# **SCOPING OPINION:**

## **Proposed White Elm Solar Farm**

**Case Reference: EN0110003**

**06 December 2024**

Figure 6.4 – Screened Zone of Theoretical Visibility

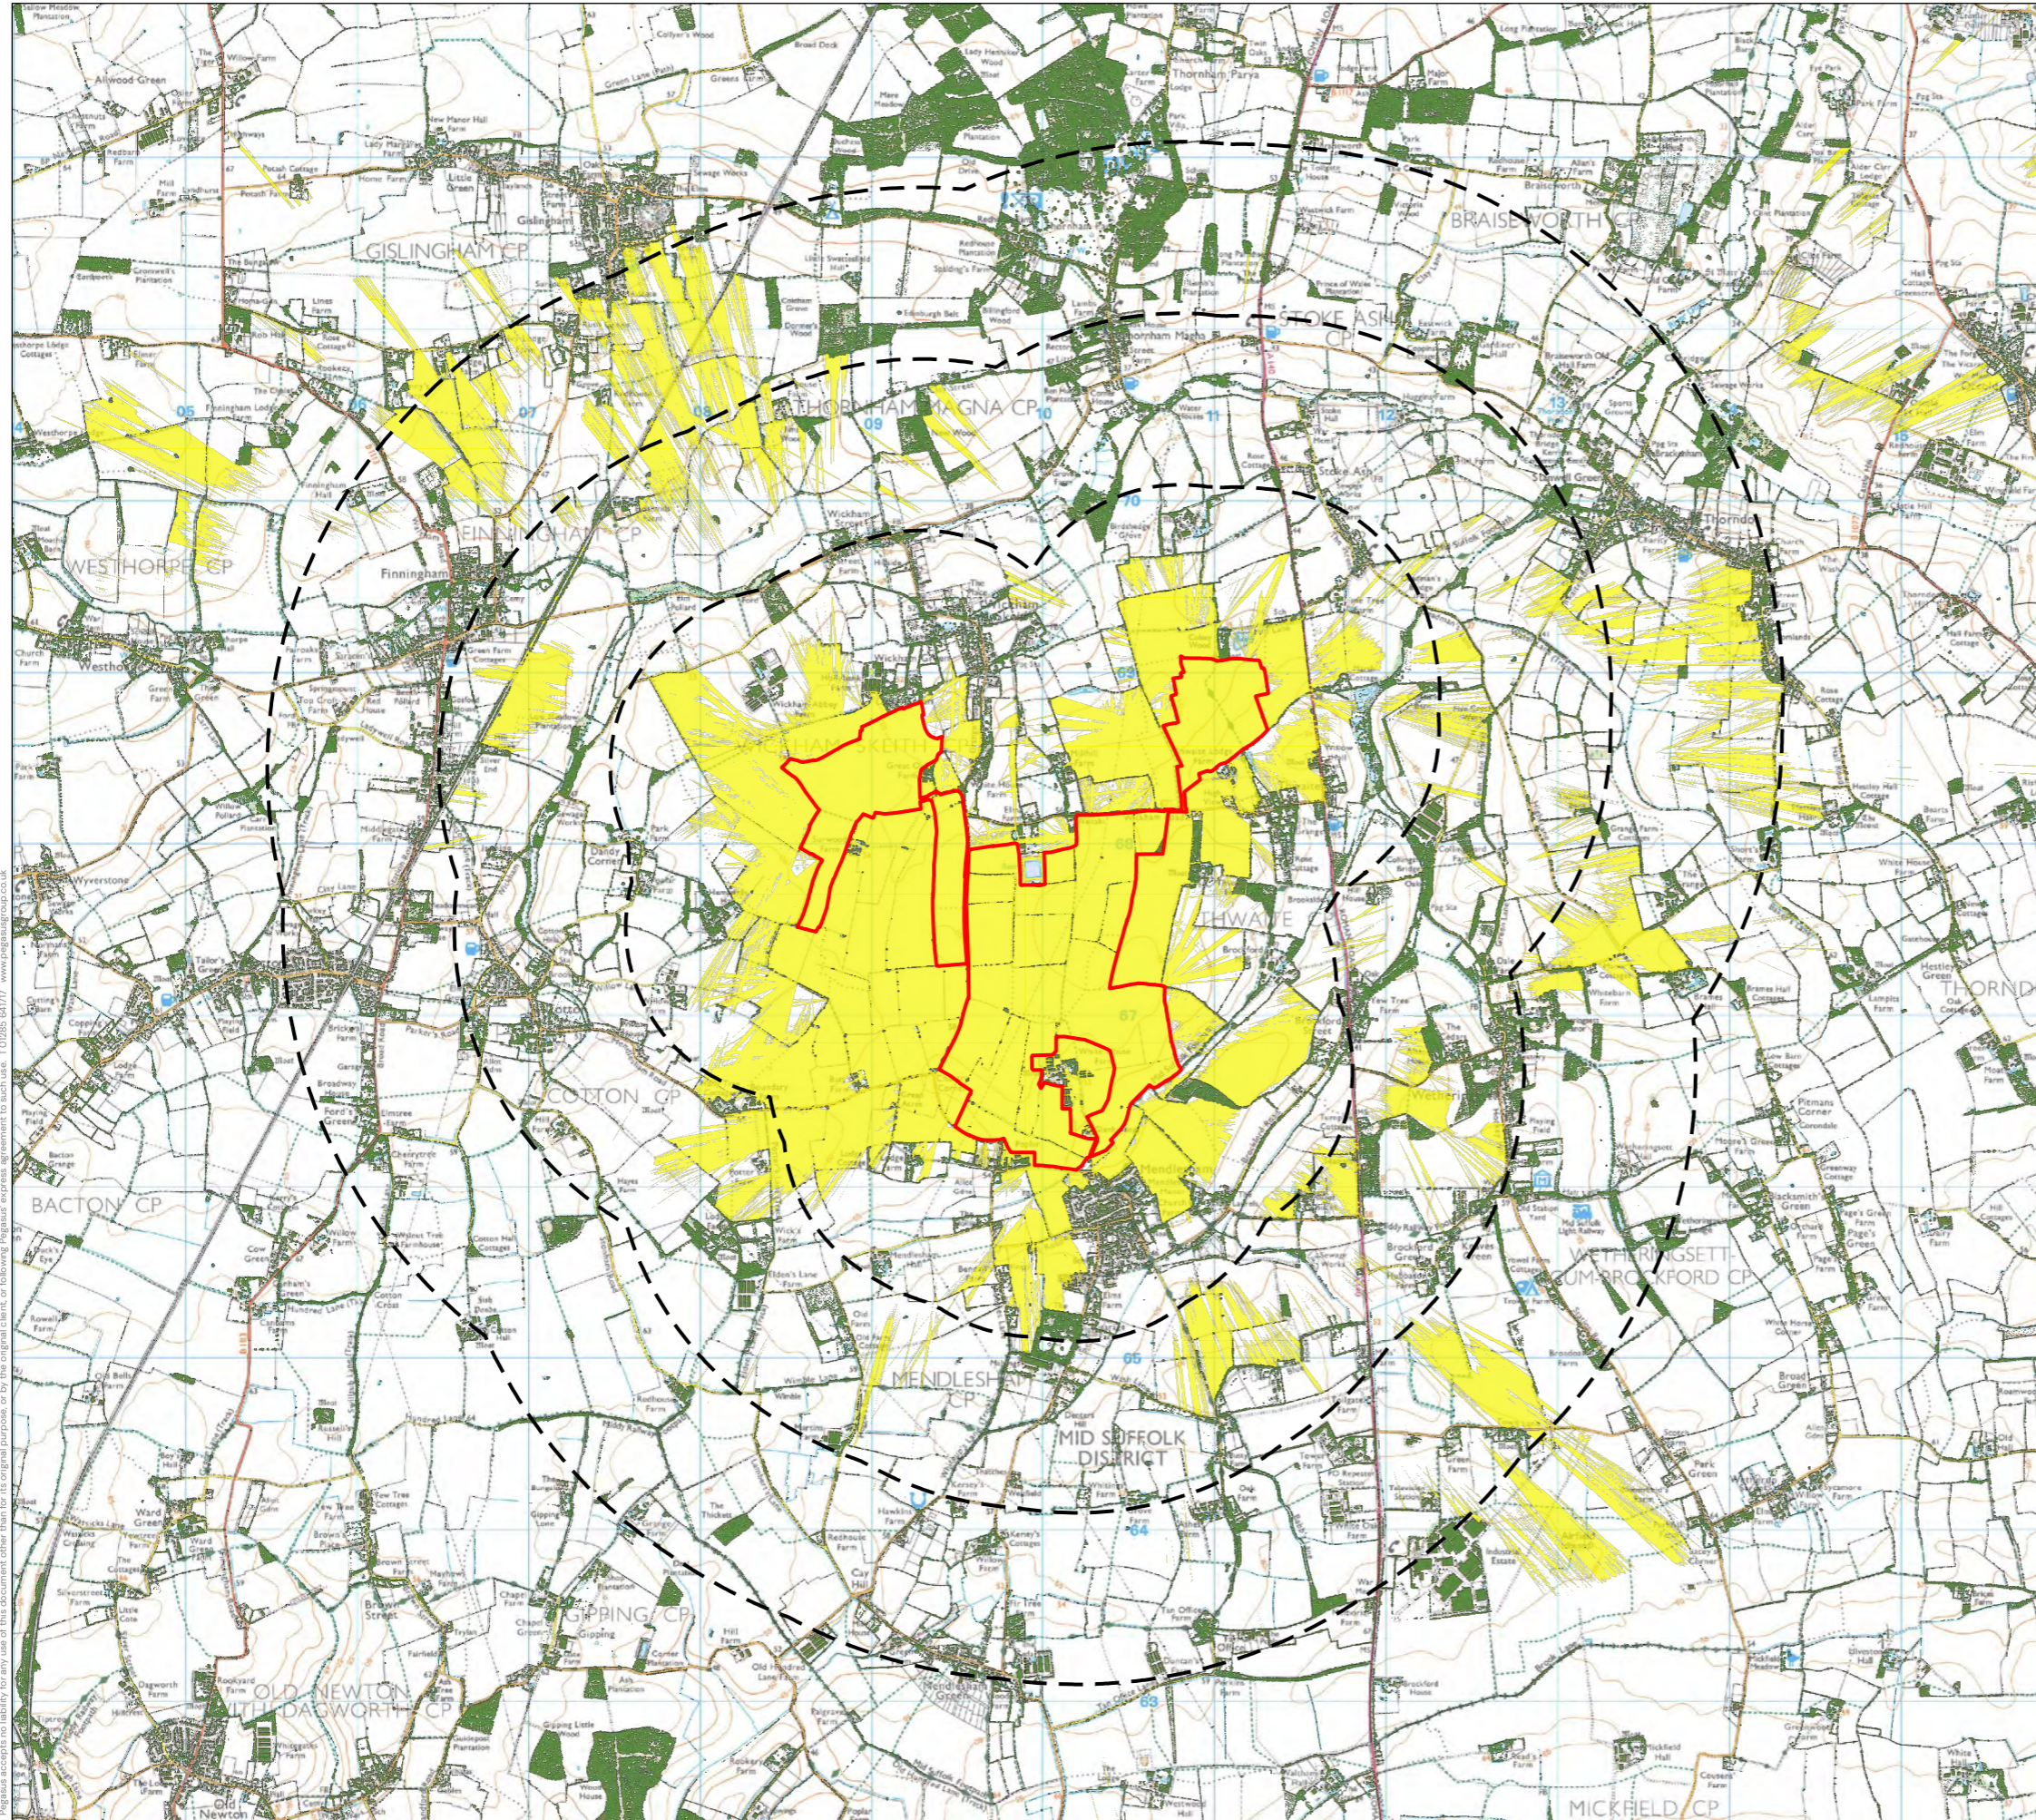
| ID  | Ref            | Applicant's proposed matters to scope out | Inspectorate's comments   |
|-----|----------------|---|---|
| 314 | Para 6.36      | Study area - SZTV                         | The Applicant should demonstrate how their approach to using a SZTV complies with the Landscape Institute's guidance on establishing a ZTV for the landscape and visual impact assessment (LVIA). The Landscape Institute's ZTV approach treats the world as 'bare earth' and does not take account of potential screening by vegetation or buildings.  |

Figure 6.5 – Viewpoint Location Plan

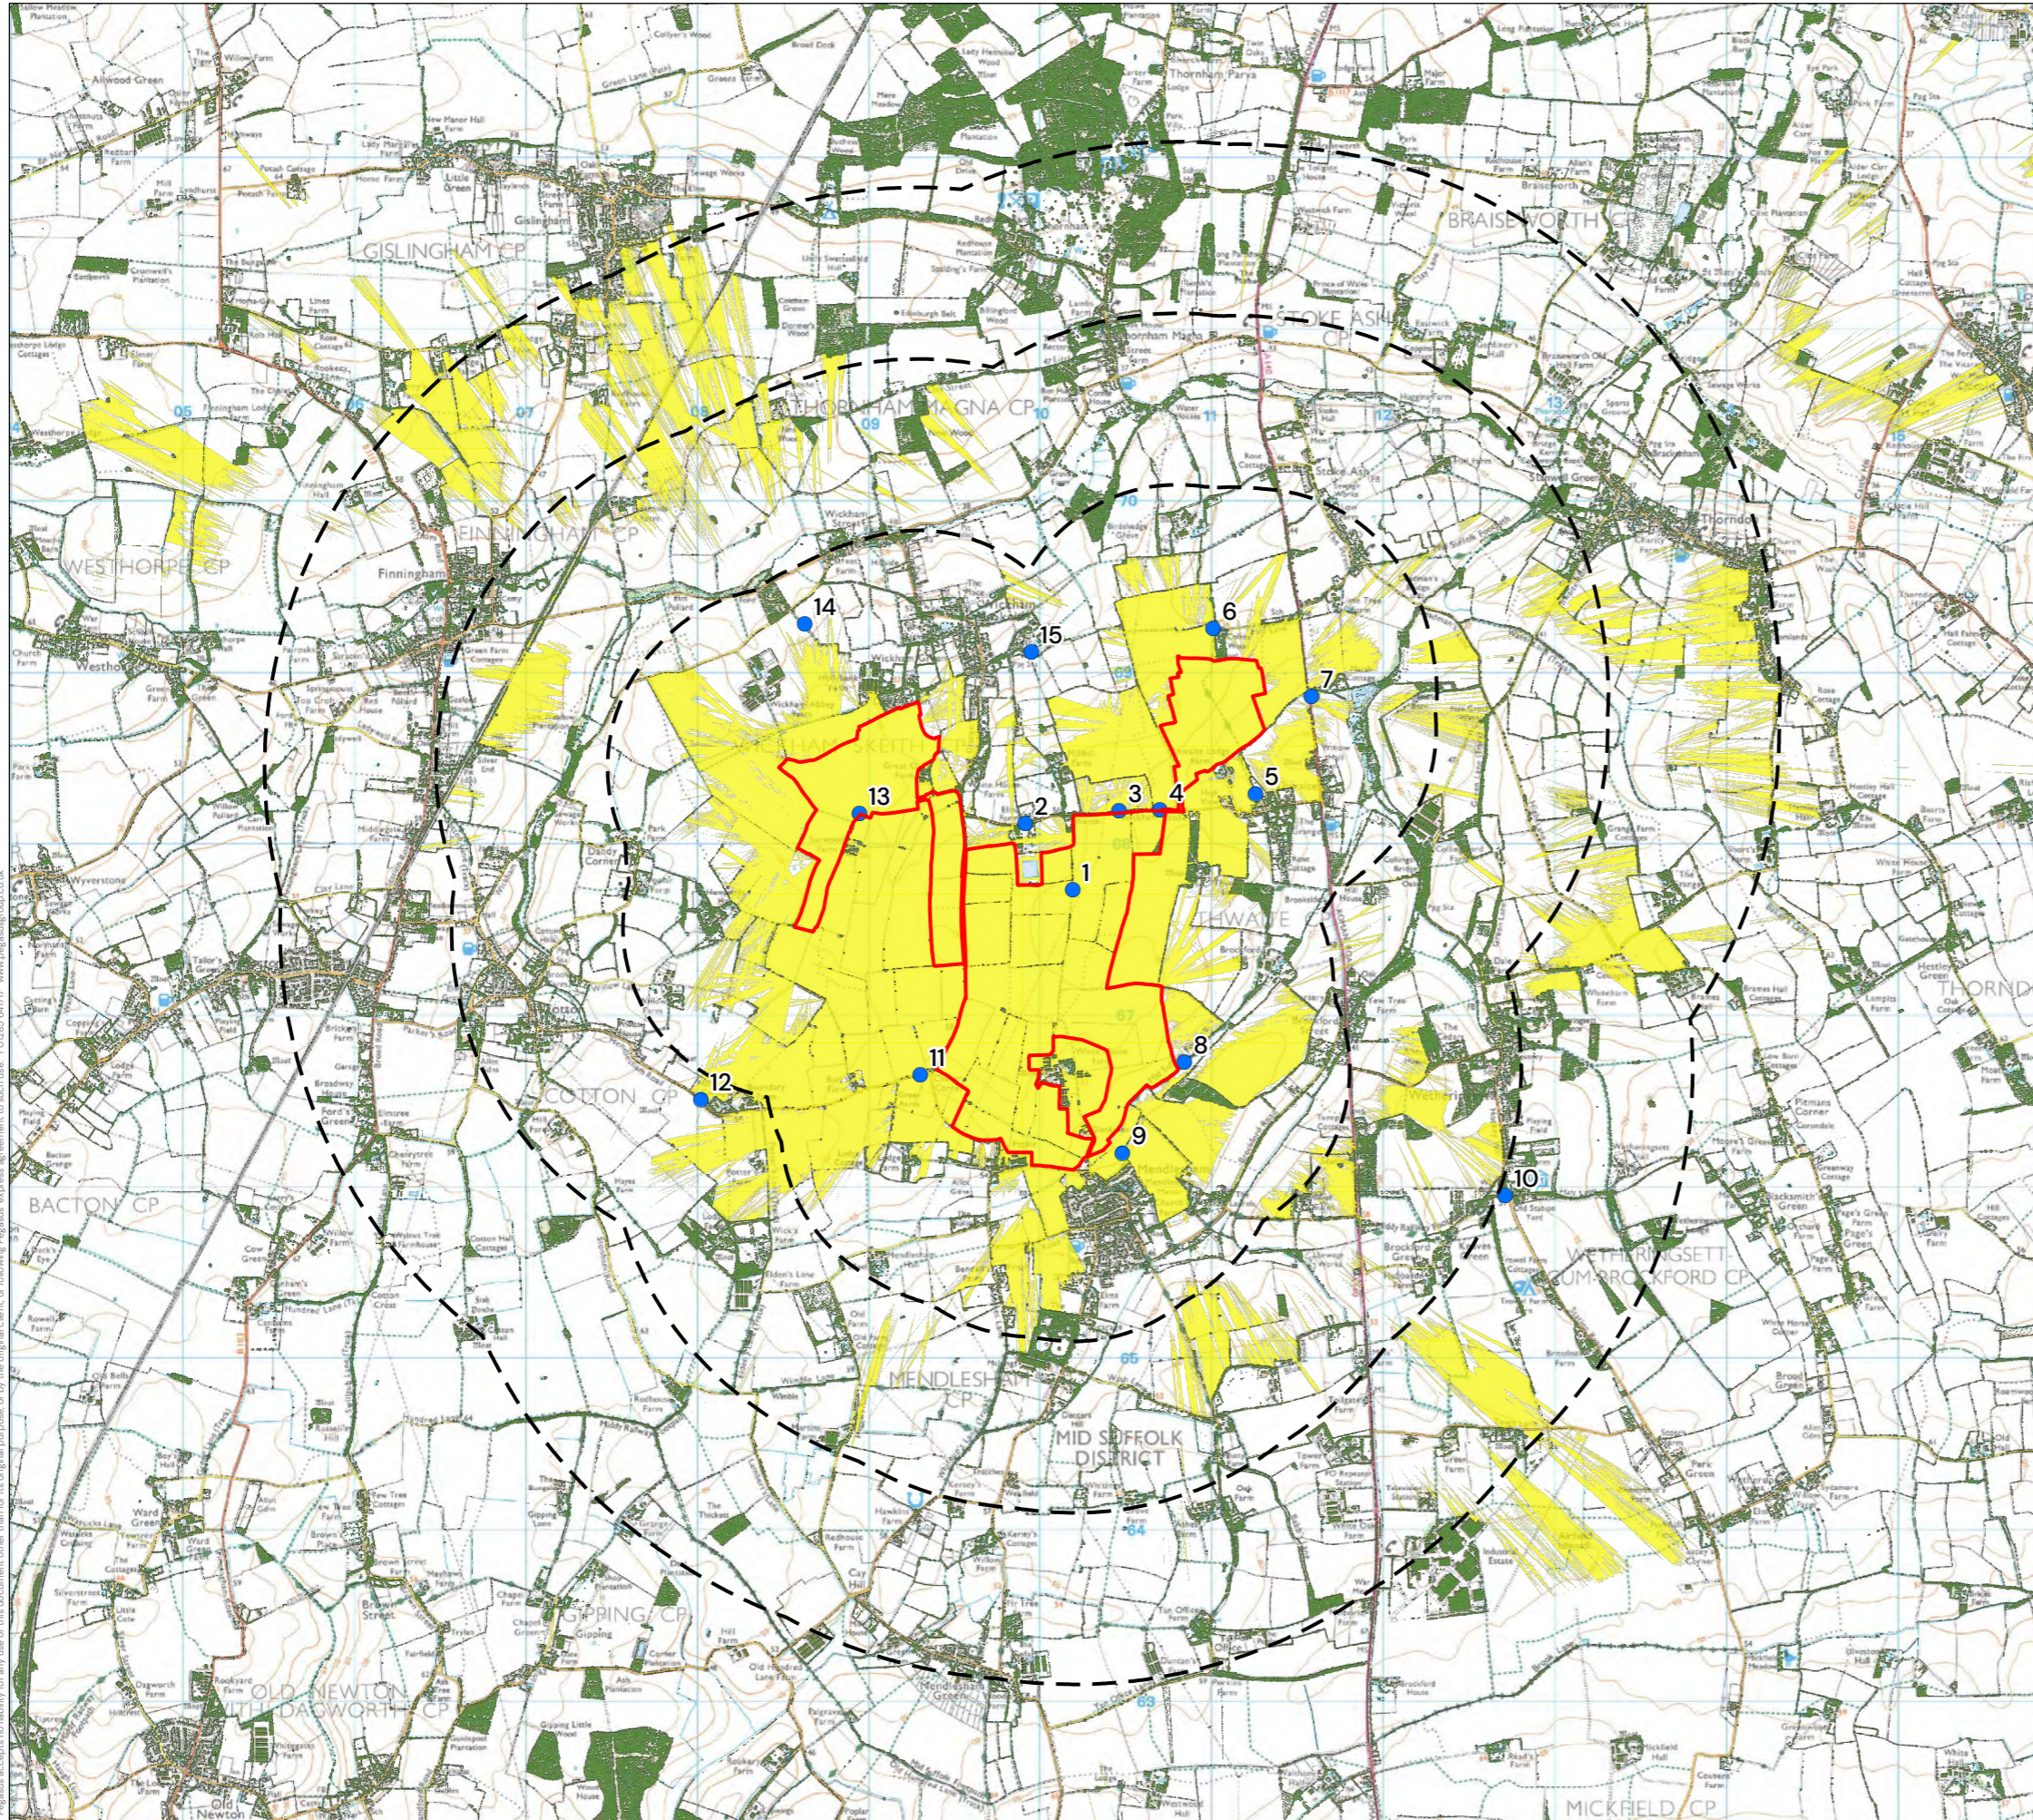
| ID  | Ref            | Applicant's proposed matters to scope out | Inspectorate's comments   |
|-----|----------------|---|---|
| 316 | Table 6.1      | Viewpoints                                | Table 6.1 sets out the proposed viewpoint locations. The Inspectorate advises that the ES should include confirmation of the consultation undertaken, together with evidence of agreement about the final viewpoint selection. Where any disagreement remains, an explanation as to how the final selection was made should be provided. Viewpoint locations should be identified on a plan within the ES. Baseline viewpoint photography for summer and winter should be provided.   |
